Condition 11- Surface Water Drainage Design

Application No: CM/11/21/DOC
Registered: 5th March 2021
Site Address: Scyld Horsemere Green Lane Climping BN17 5QZ
Description of Works: Approval of details reserved by condition imposed under CM/21/19/PL relating to conditions 11-surface water drainage scheme, 12-discharge of flows to water courses or for the culverting, diversion, infilling or obstruction of any water course on or adjacent to site & 13-maintenance and management of surface water drainage system.

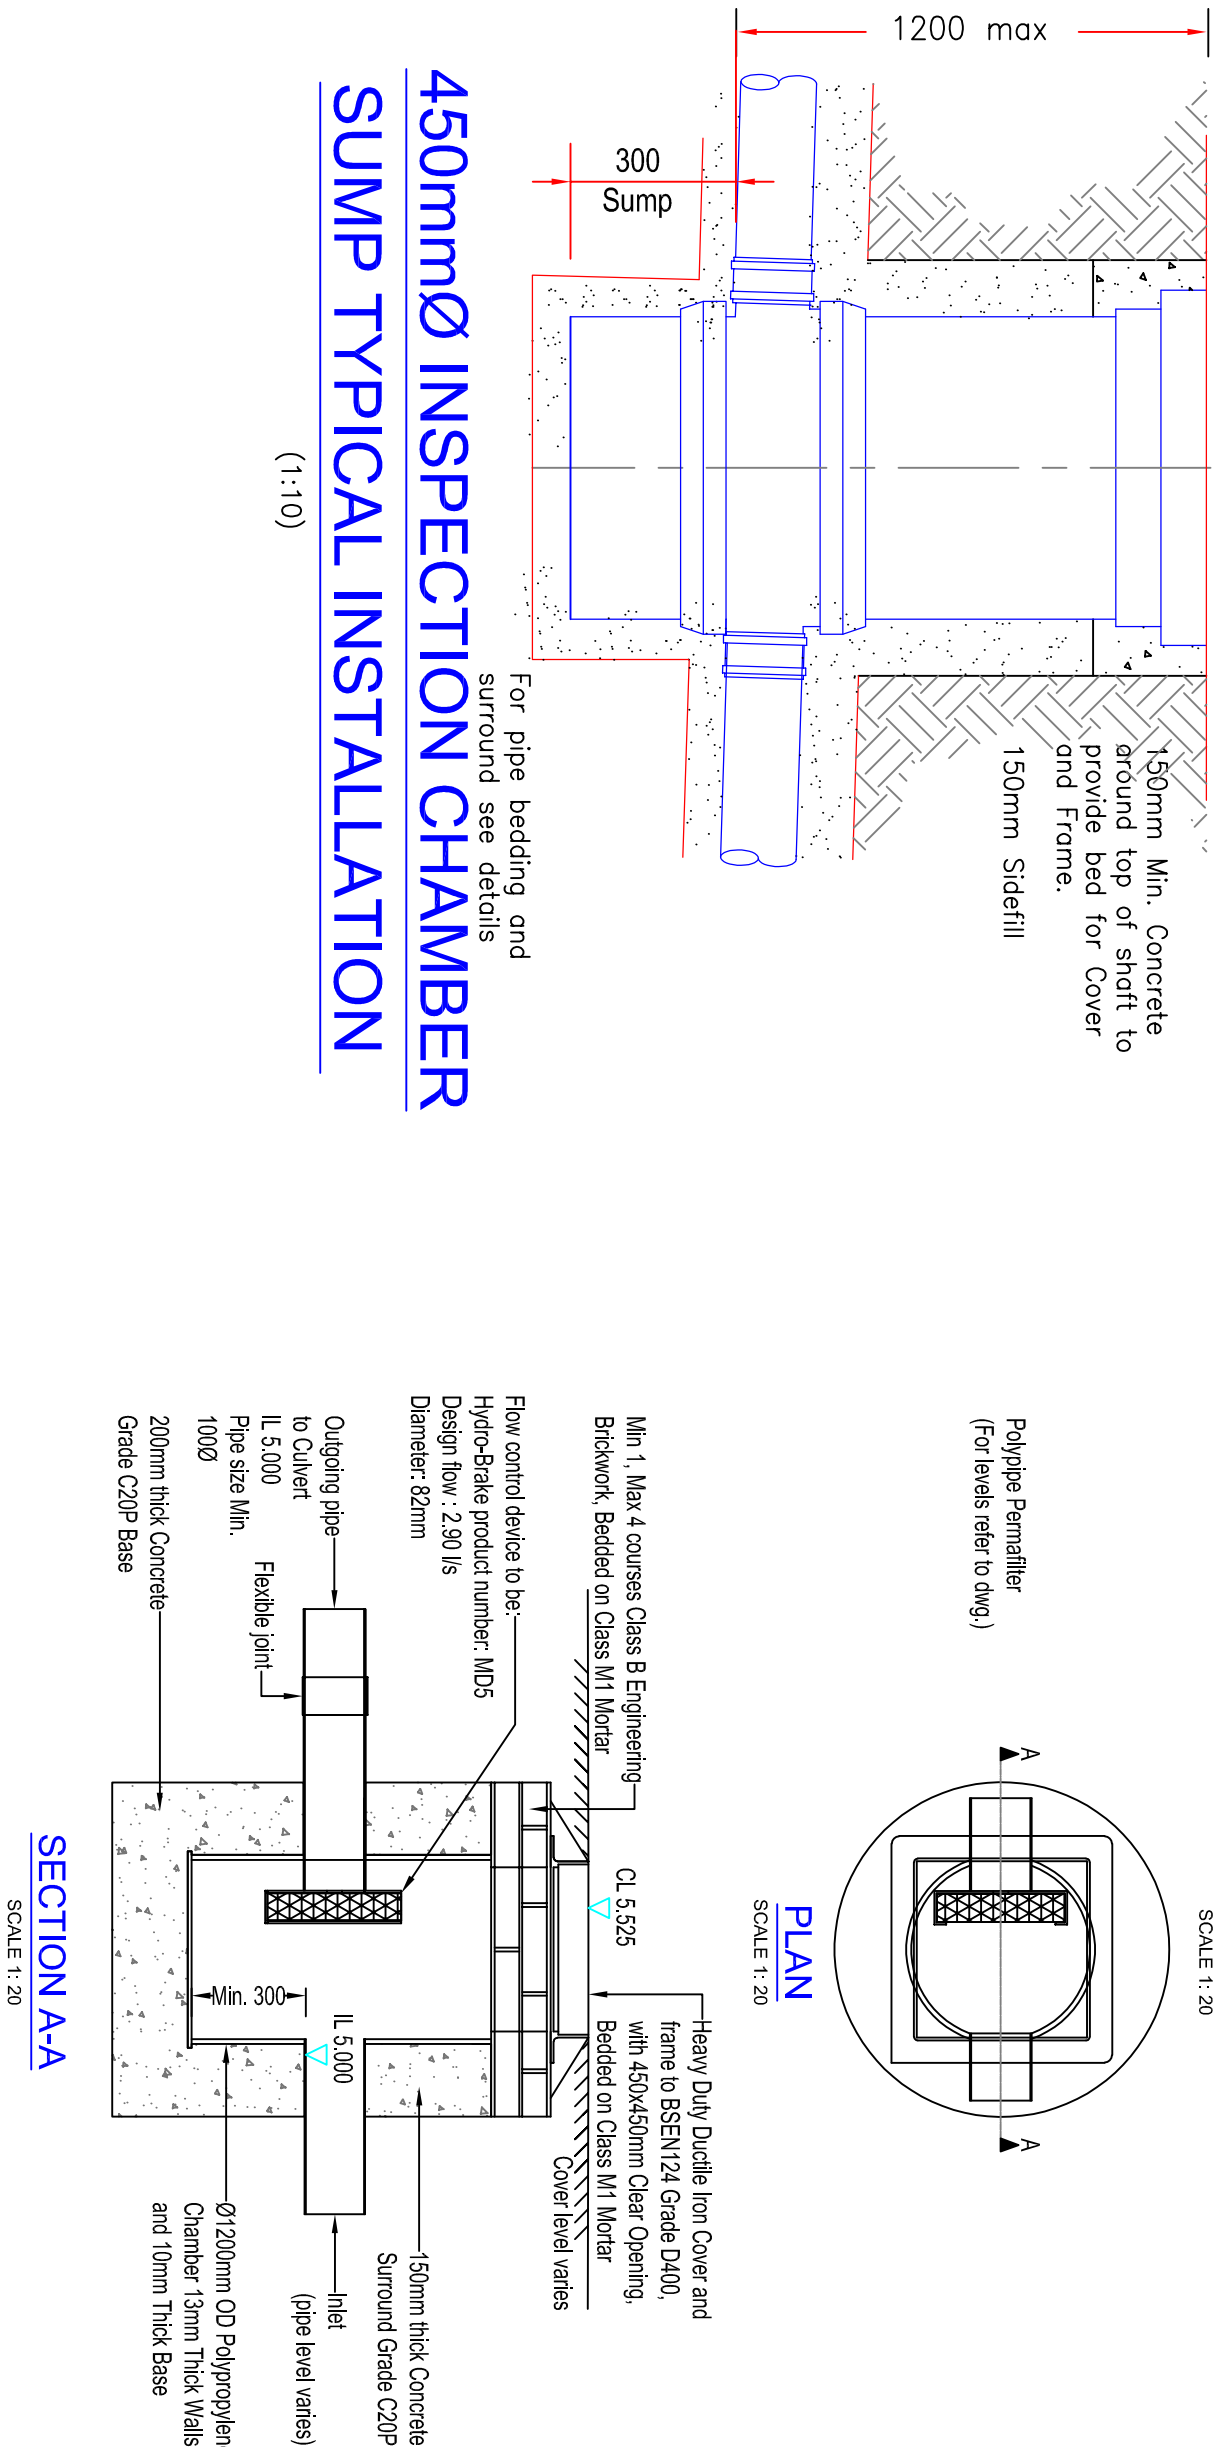
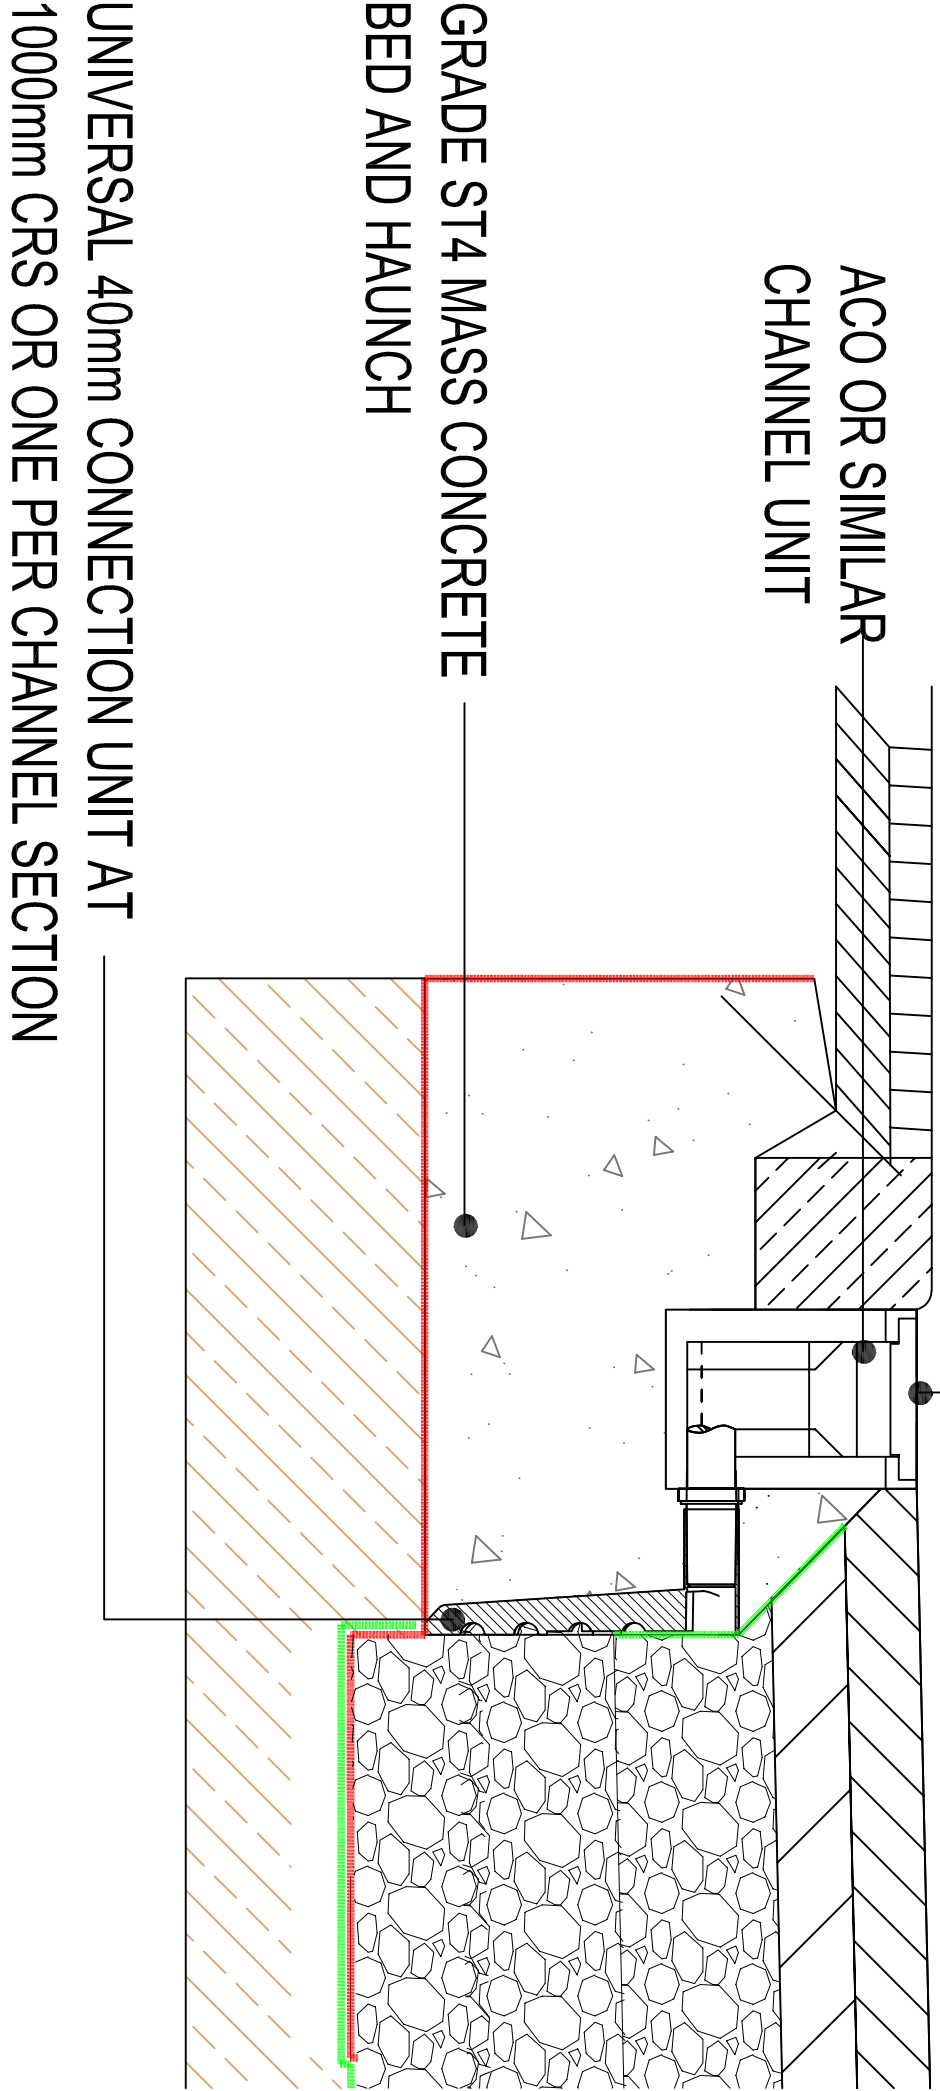
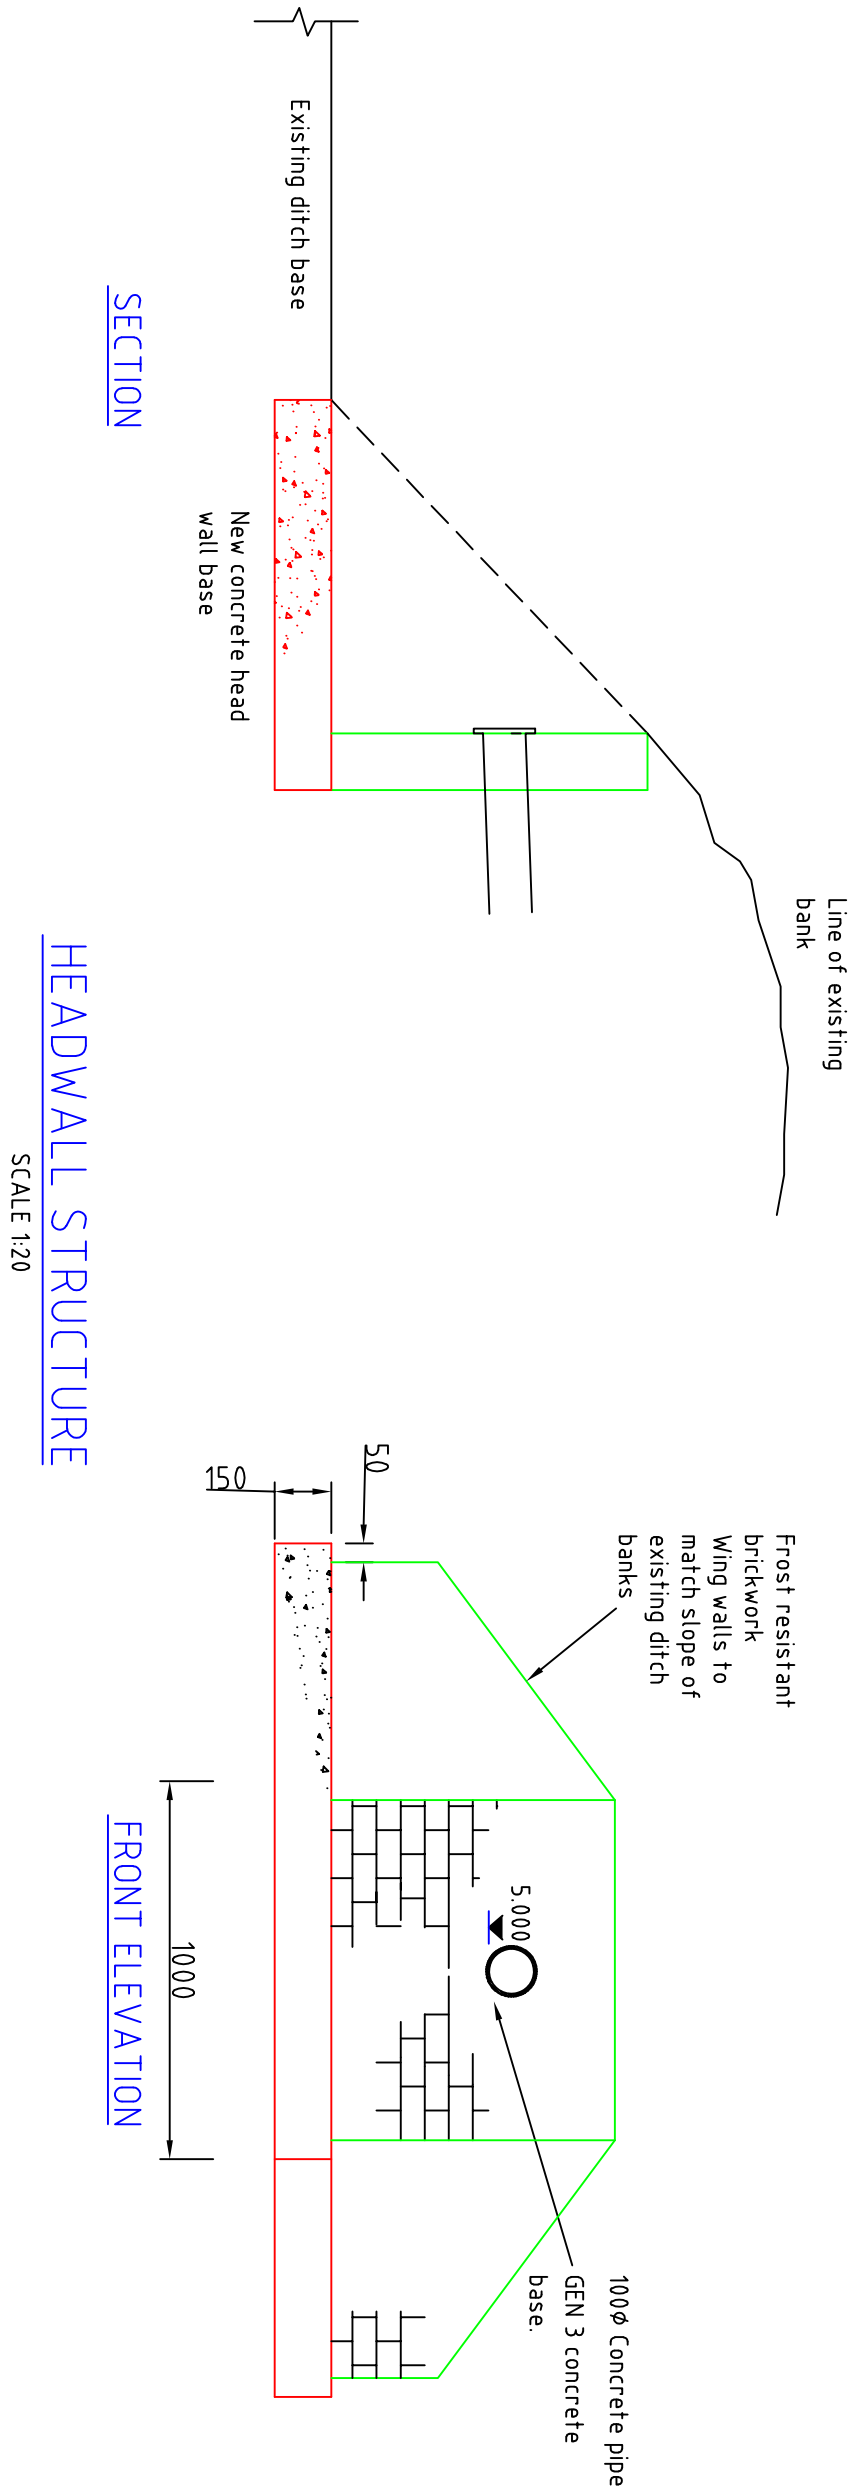
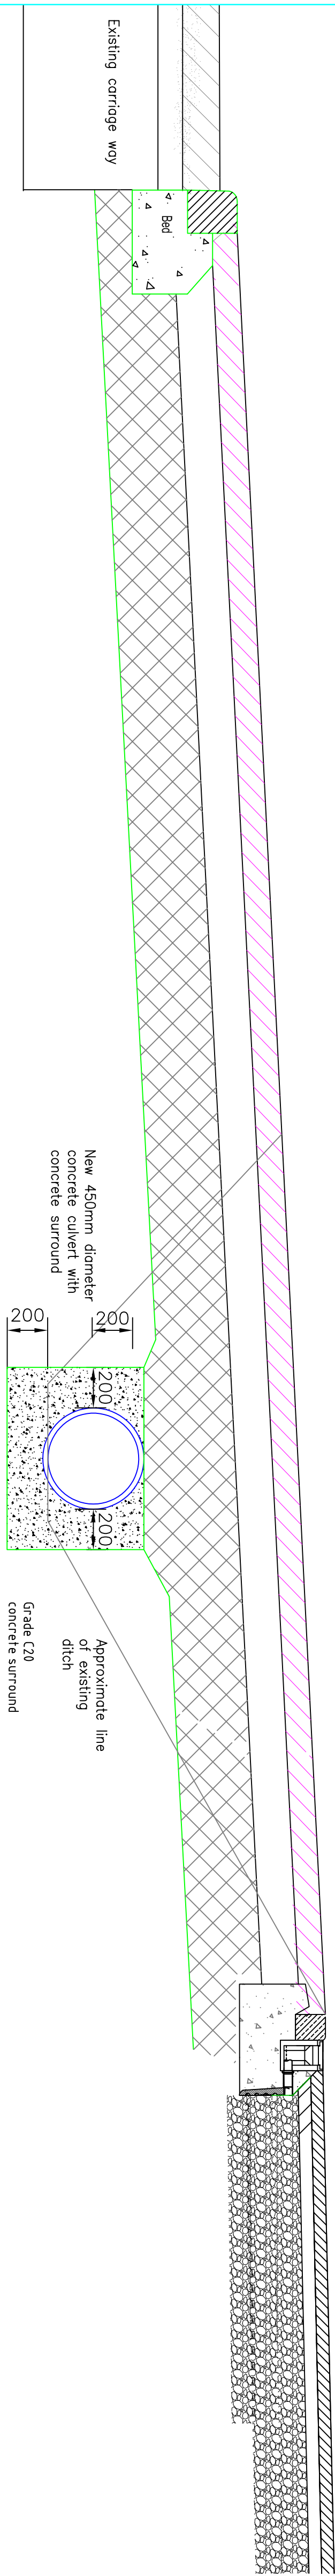
3. The long section on the drainage details sheet 1 refers to a hydrobrake with a restriction of 2.0l/s, which conflicts with the calculations, other details and layout (although addressing point 1 will affect these). This is now correct after the revised calculations, other details have been updated accordingly.

3. The long section on the drainage details sheet 1 refers to a hydrobrake with a restriction of 2.0l/s, which conflicts with the calculations, other details and layout (although addressing point 1 will affect these). This is now correct after the revised calculations, other details have been updated accordingly. See comment below.
